April 14, 2022

Regarding: Reasonable Use Exception RU-22-00002 East Peak

**WETLAND BUFFER
ENHANCEMENT PLAN**

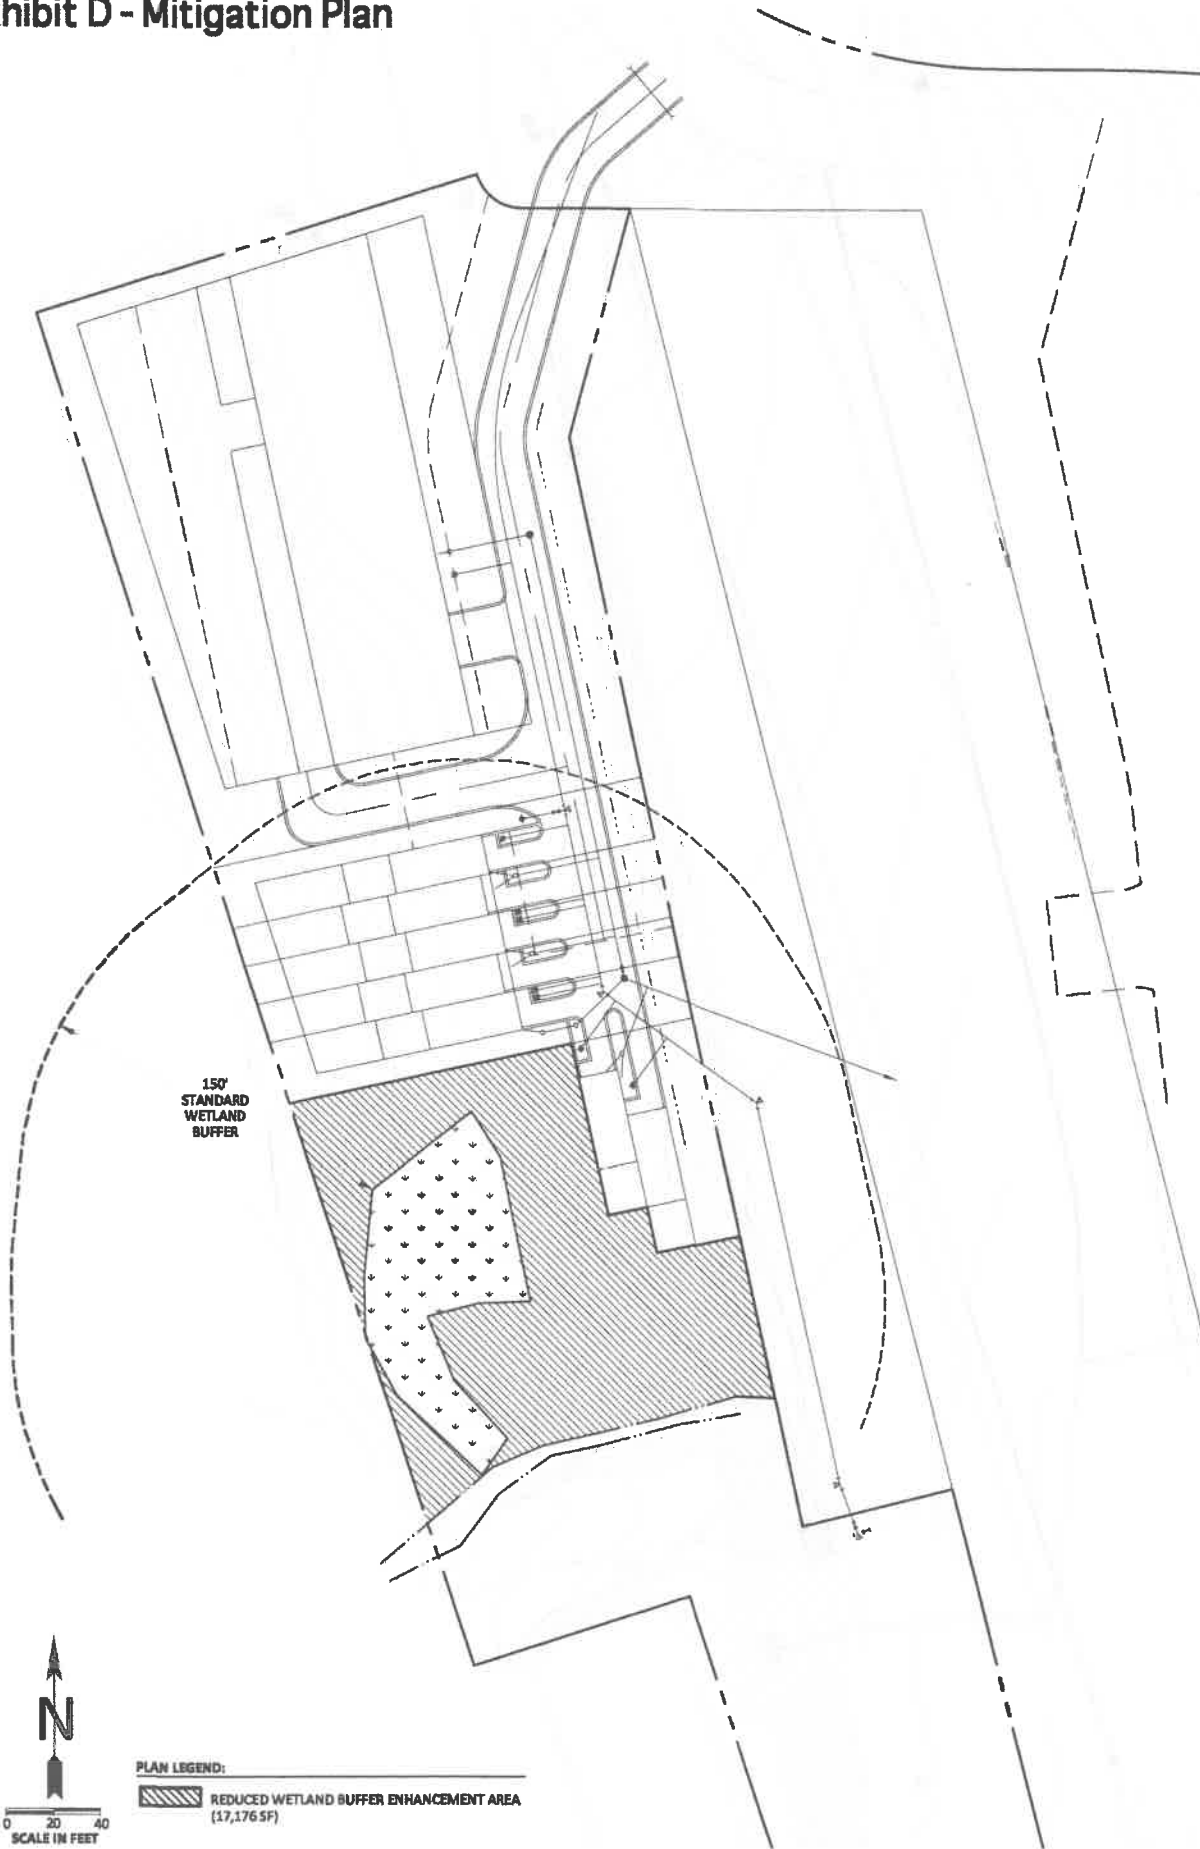
In reading the Wetland Buffer enhancement plan, I noted that it stated that the wetlands would be cleaned of gravel. My concern is that the wetland would continue to see snow removal thrown onto the enhanced buffer. In fact with reduced area for snow removal due to the new buildings, the wetland area would more than likely become the primary snow holding area for the parking lot resulting in a further degradation of the wetland area.

EXHIBIT A - PROPOSED SITE PLAN

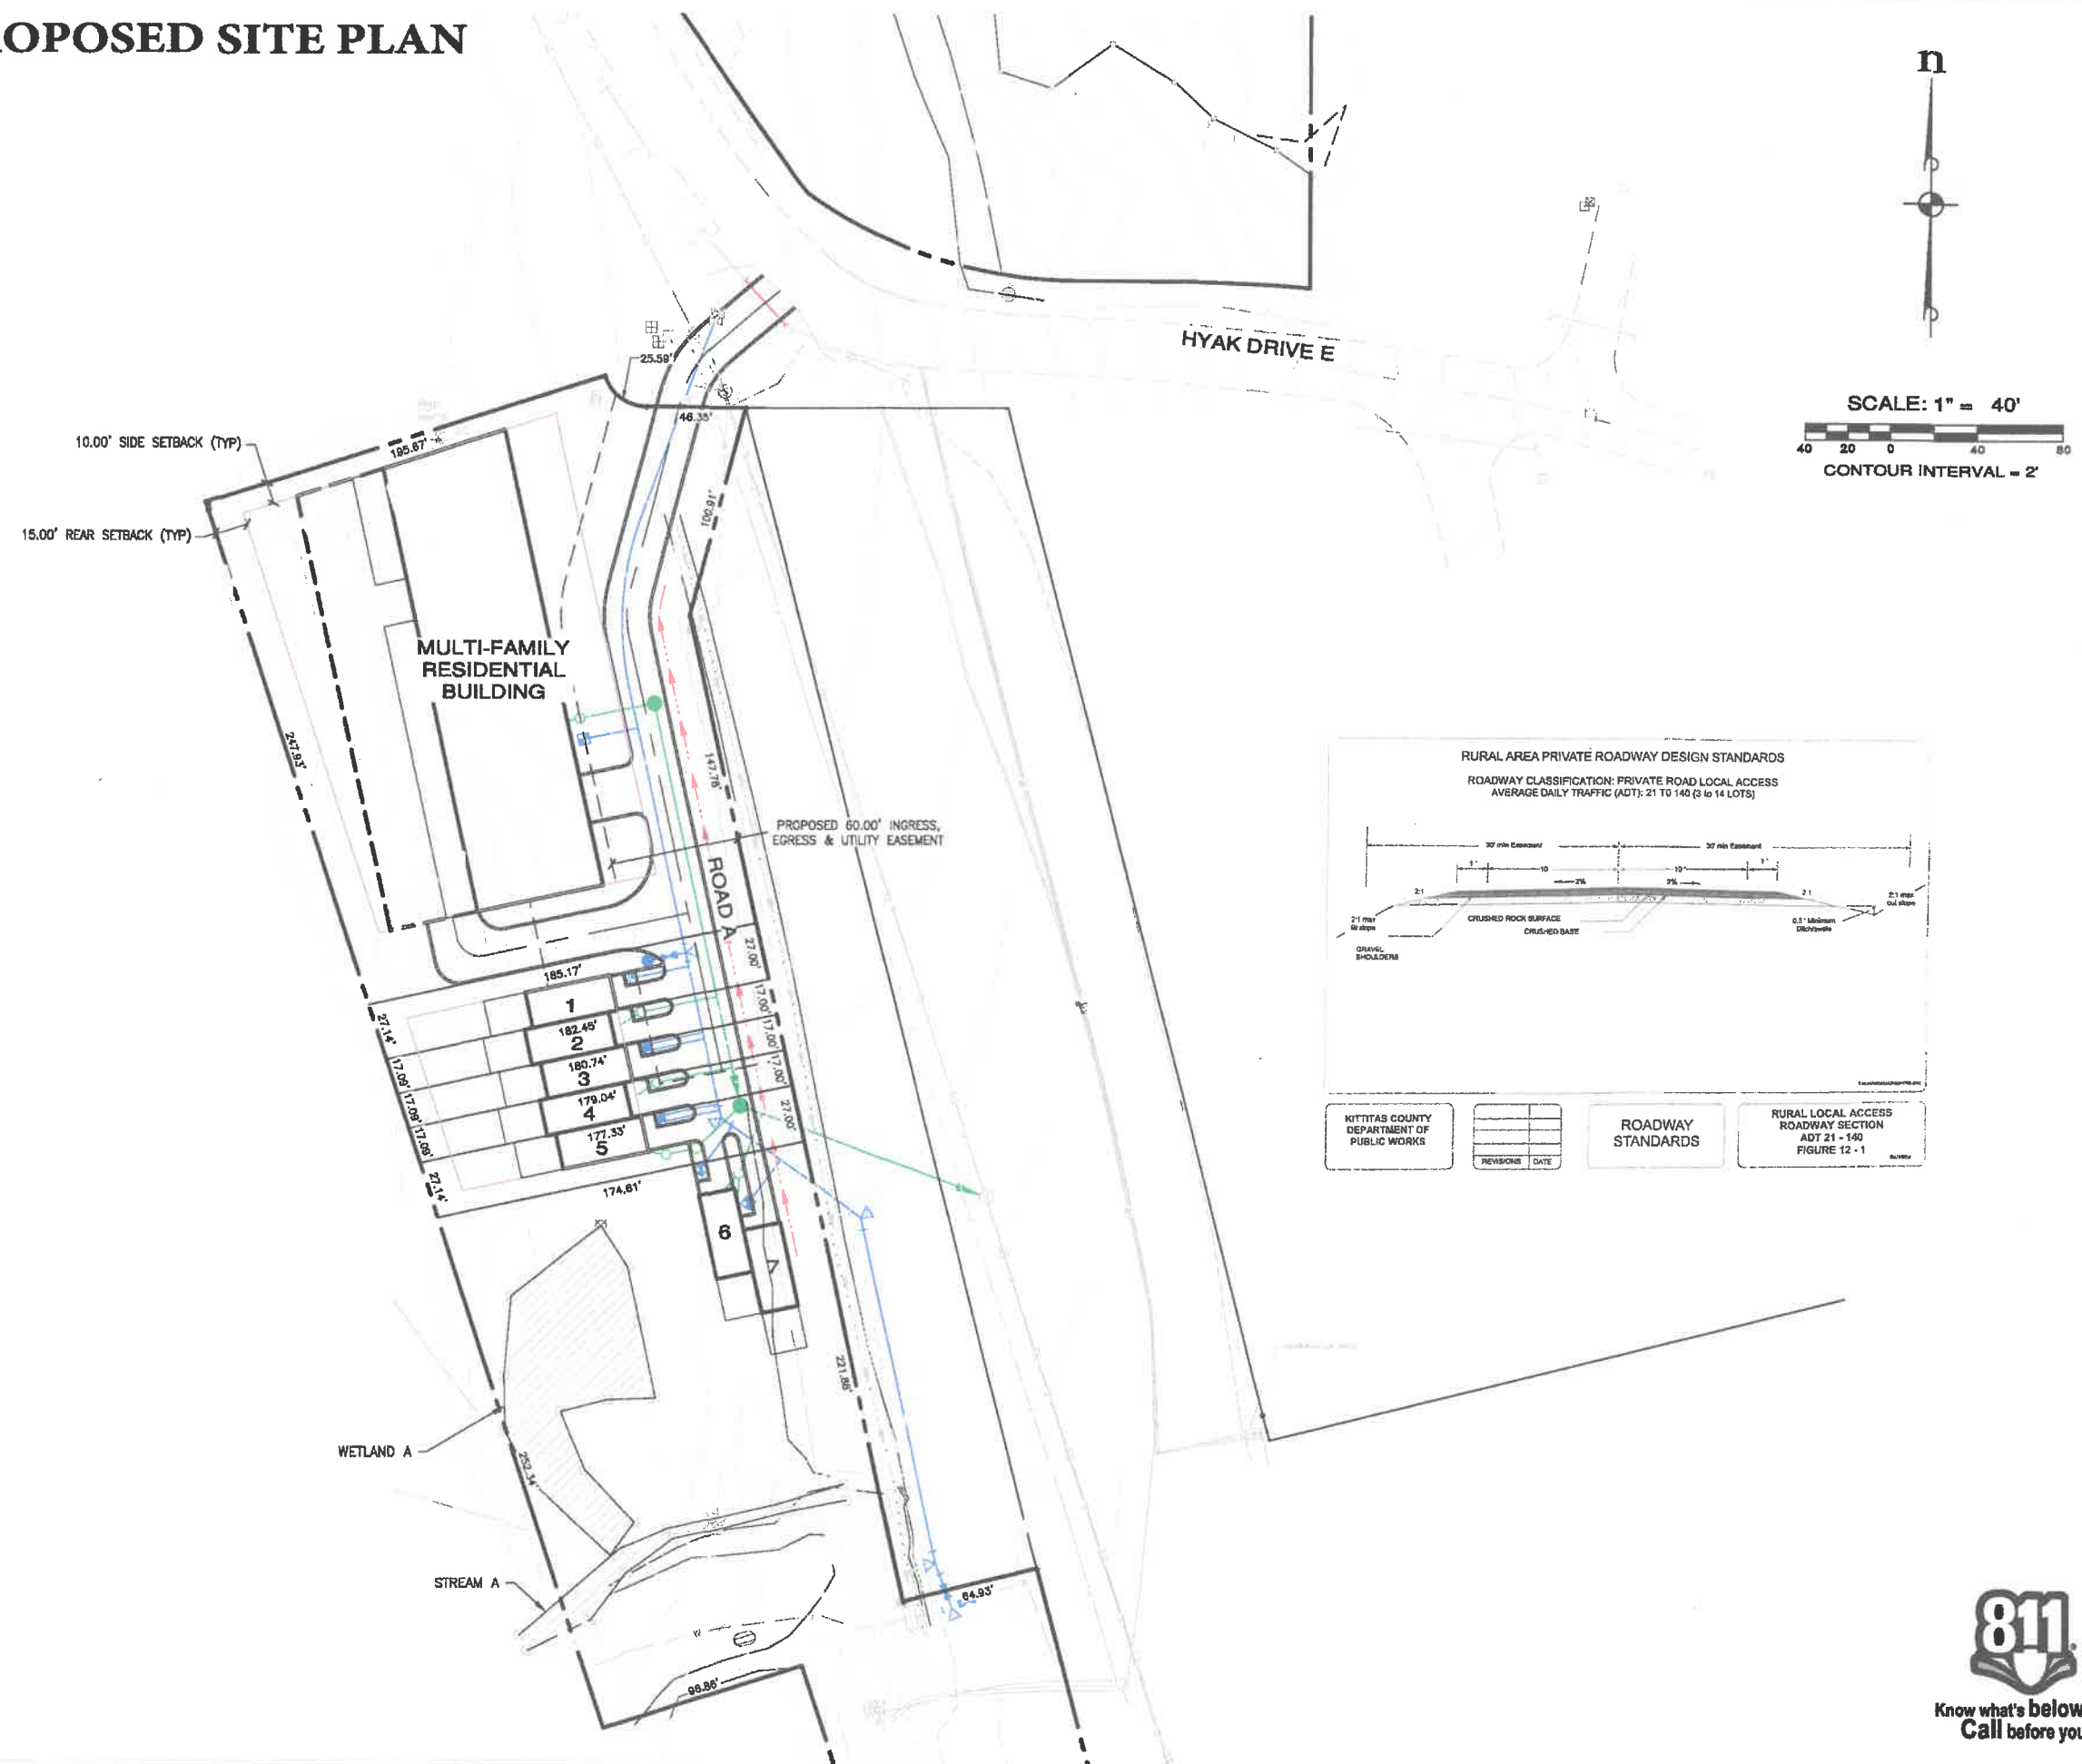
In regards to the reduced wetland buffer, I find it odd that none of the documentation seems to specify the final reduced buffer. The original buffer for a type 3 wetland is indicated at 150 feet plus 15 foot setback. In looking at the Proposed Site Plan the distance is not called out, but it appears that the type 3 wetland buffer has been reduced from 150 feet to 25 feet with a ten foot building setback. This seems to be an extreme reduction in the buffer zone. A total reduction of approximately 125 feet. The primary reason for the reduction does not appear to have any environmental rational. The only reason given in asking for the reasonable use exception is that East Peak development would like to maximize their financial return on this project. Nowhere in the wetland evaluation does it mention that this is a newly created wetland, so it must be assumed that this wetland was present when East Peak originally purchased this land and it would seem that they should have conducted due diligence prior to purchasing this particular plat. It does not seem that Kittitas County should be required to waive environmental standards solely that East Peak can maximize its profit. With regards to the current real estate market it would seem probable that, even if the buildable plat is reduced by 40 to 50 percent, the project should maintain a healthy profit.

In regards to flipping the design layout, with the condominium at the North end, it appears that this may have a negative effect for the existing residential homes on Chamonix Pl. Nowhere in the plans does it indicate the height of the proposed condo, but I would imagine that having a 40 to 60 foot tall building will have a detrimental effect on existing housing located due west and north of the condo.
